Struthers Ranch Polaris Grading & Erosion Control Plans El Paso County, Colorado

EPC STORMWATER REVIEW COMMENTS
 IN ORANGE BOXES WITH BLACK TEXT

STRUTHERS RANCH POLARIS
 LOTS 1-2, STRUTHERS RANCH SUBDIVISION FILING NO. 4

GEC PLAN
 TITLE SHEET

# SITE GRADING AND EROSION CONTROL PLAN

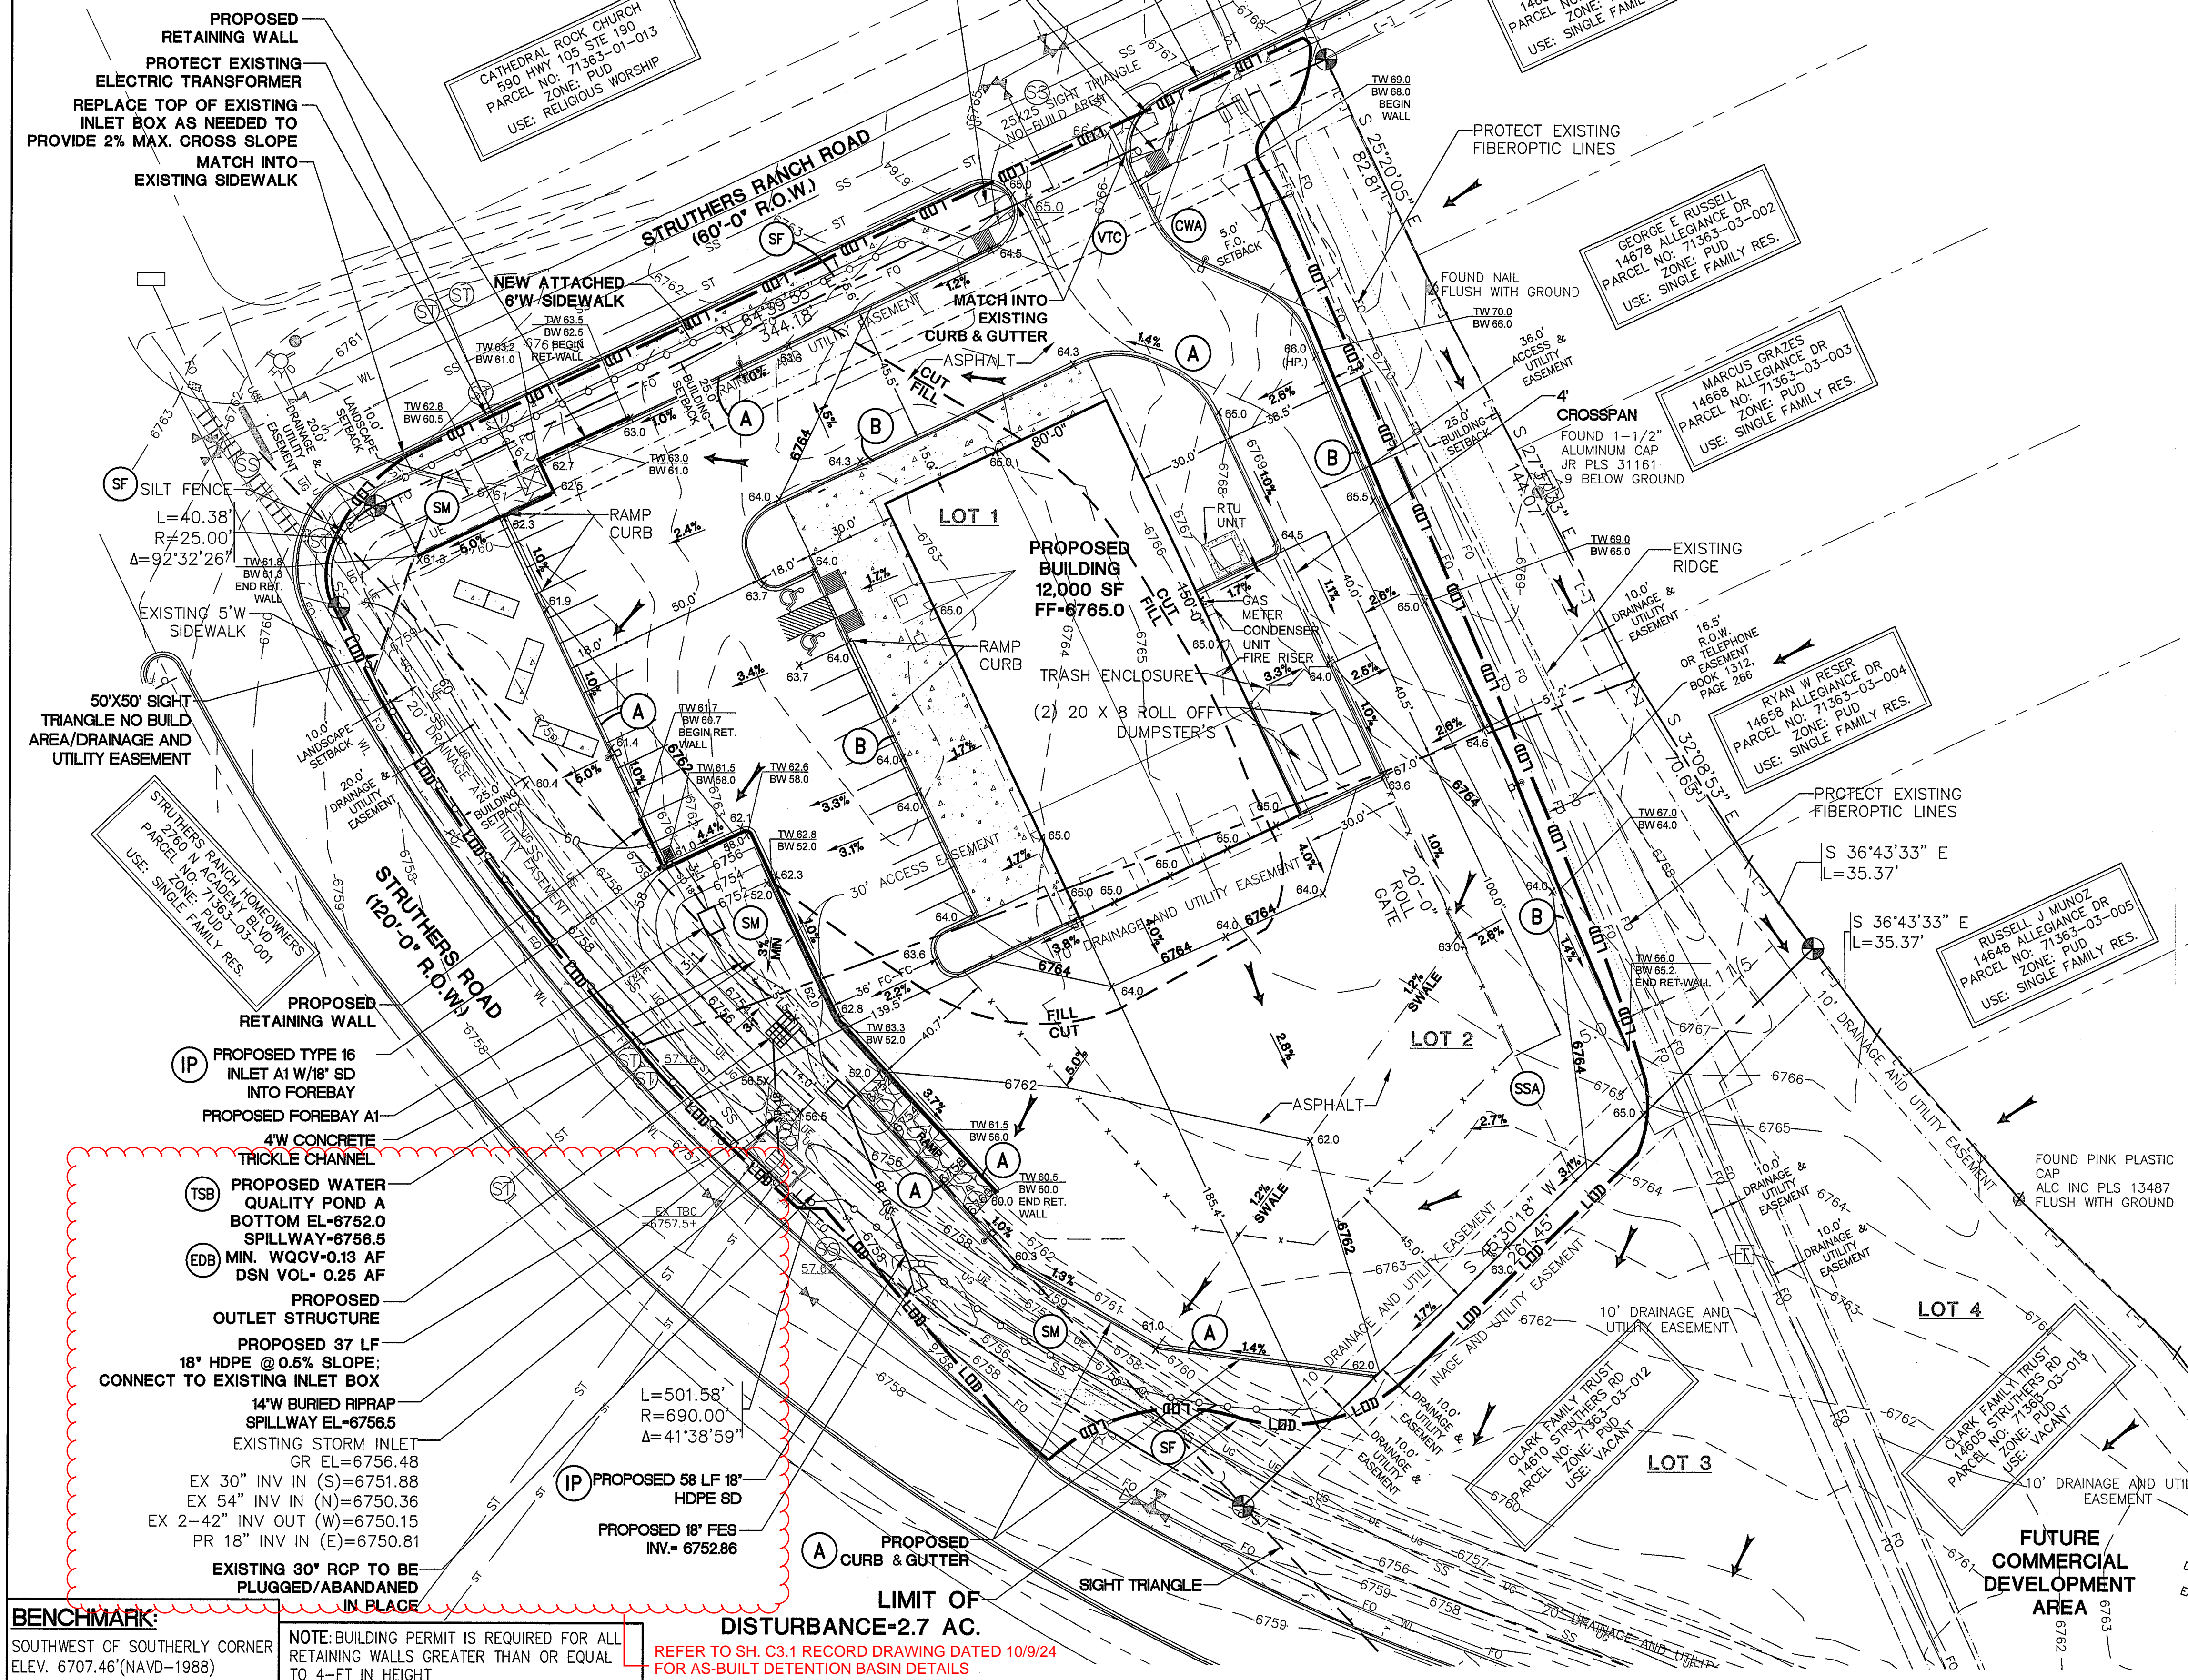
Please show the differences from design to as-built conditions in red text with red clouds/bubbles.

SECTION  
TYPICAL DETENTION POND OUTLET STRUCTURE (C)  
SCALE: NTS

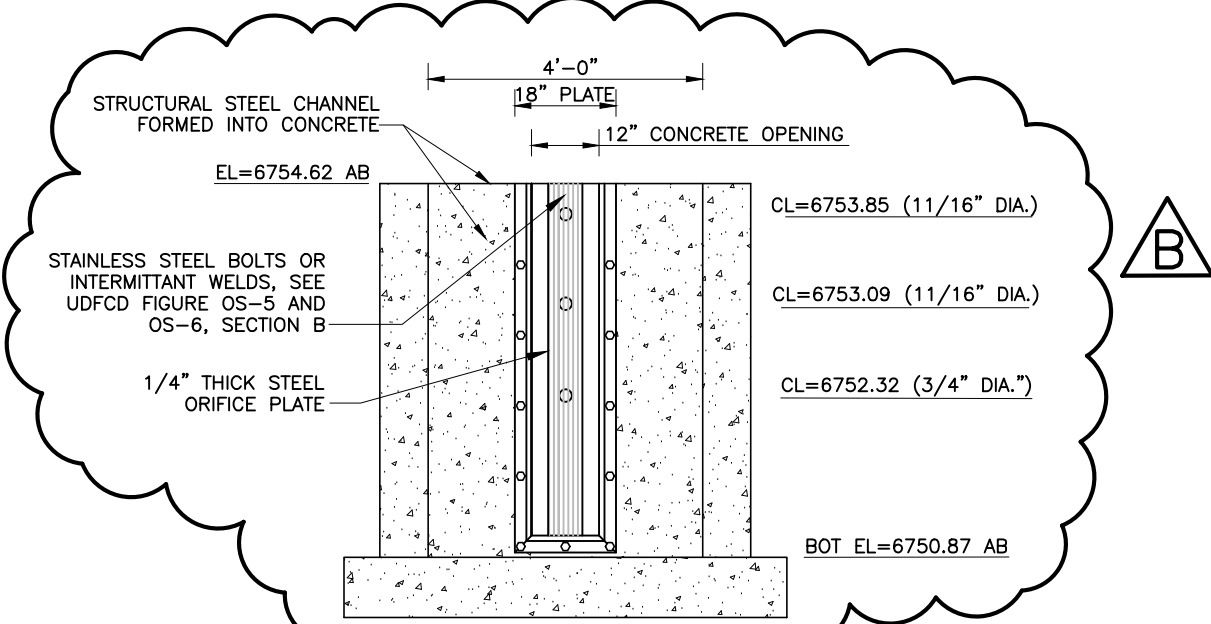
Outfall structure was measured as 3'9" tall in the field, as opposed to 6' on the plans. Install per approved plans or confirm with your project engineer that this change from the plans is acceptable and then reflect the change on the as-builts.

Cannot see bottom two holes in the field. Access elevations. As mentioned above, the entire structure appears to be smaller than what is on the approved plans. Distance from outfall pipe invert to trash rack is 2.2'. Plans call for 3.5'. Revise in field and/or update on as-builts and MHD calcs.

ORIFICE PLATE AND TRASH RACK  
DETAILS AND NOTES (D)  
NTS

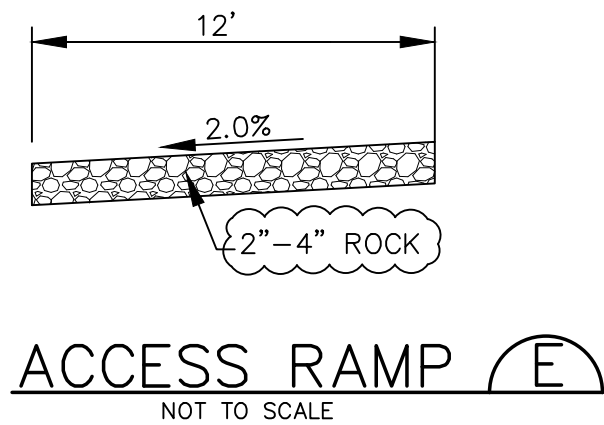
12" Concrete opening width is covered with Johnson Vee Wire with 1/2" gap. Show on as-builts.

Vertical Trash Screen: Plans call for Amico-Klemp Bar screen. Johnson Vee Wire is installed. Show on as-builts.

PROPOSED SPILLWAY DETAIL (F)  
NTS

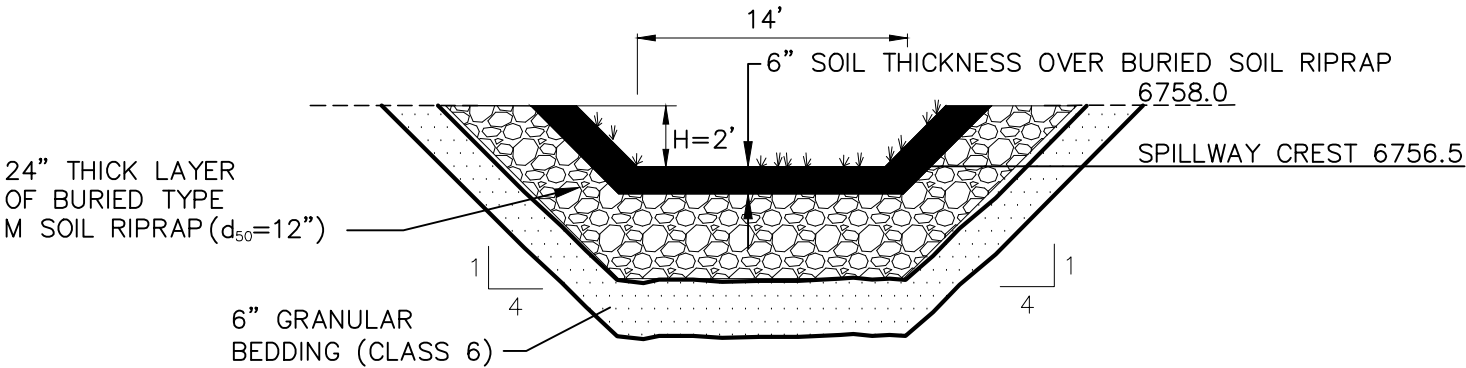
Our inspectors saw river rock was installed in the field instead of gravel. Verify that this is acceptable (for driving and isnt erodible) and then update this detail accordingly.

TYPICAL INTEGRAL FOREBAY DETAIL (FOREBAY A1 & B1) (A)  
NTS

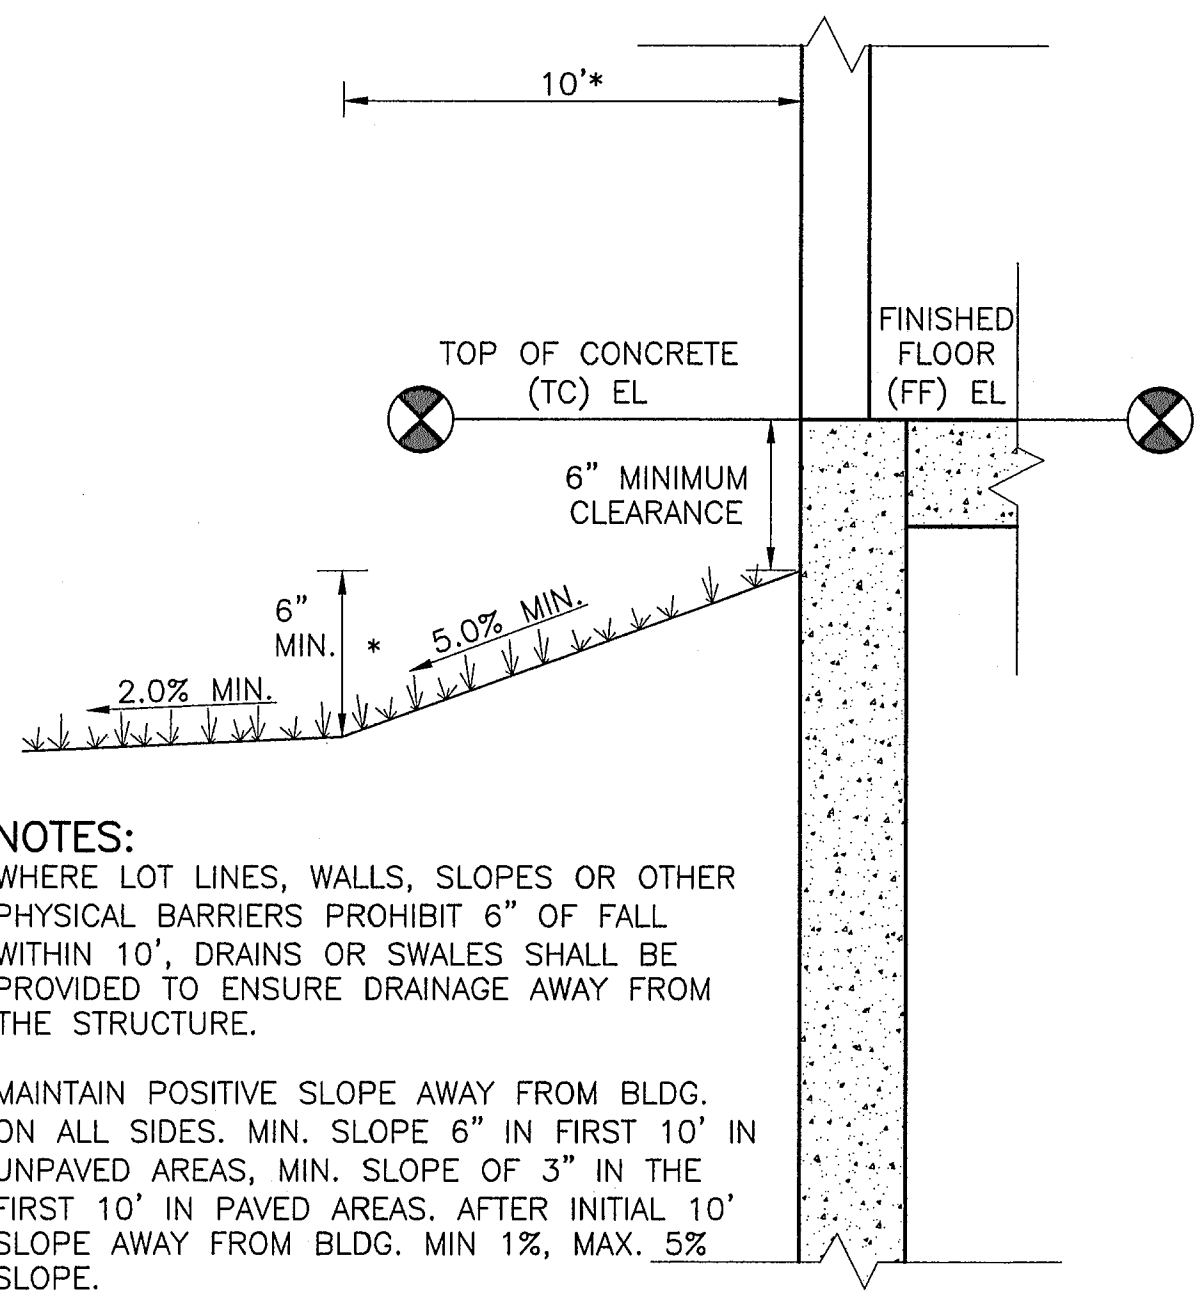
Please verify this depth. Our inspectors noticed that this was shallower than 0.5' in the field, closer to 1'.

Please verify the L and H of the baffle. Our inspectors measured it in the field to be closer to 2x2' than 3x2'.
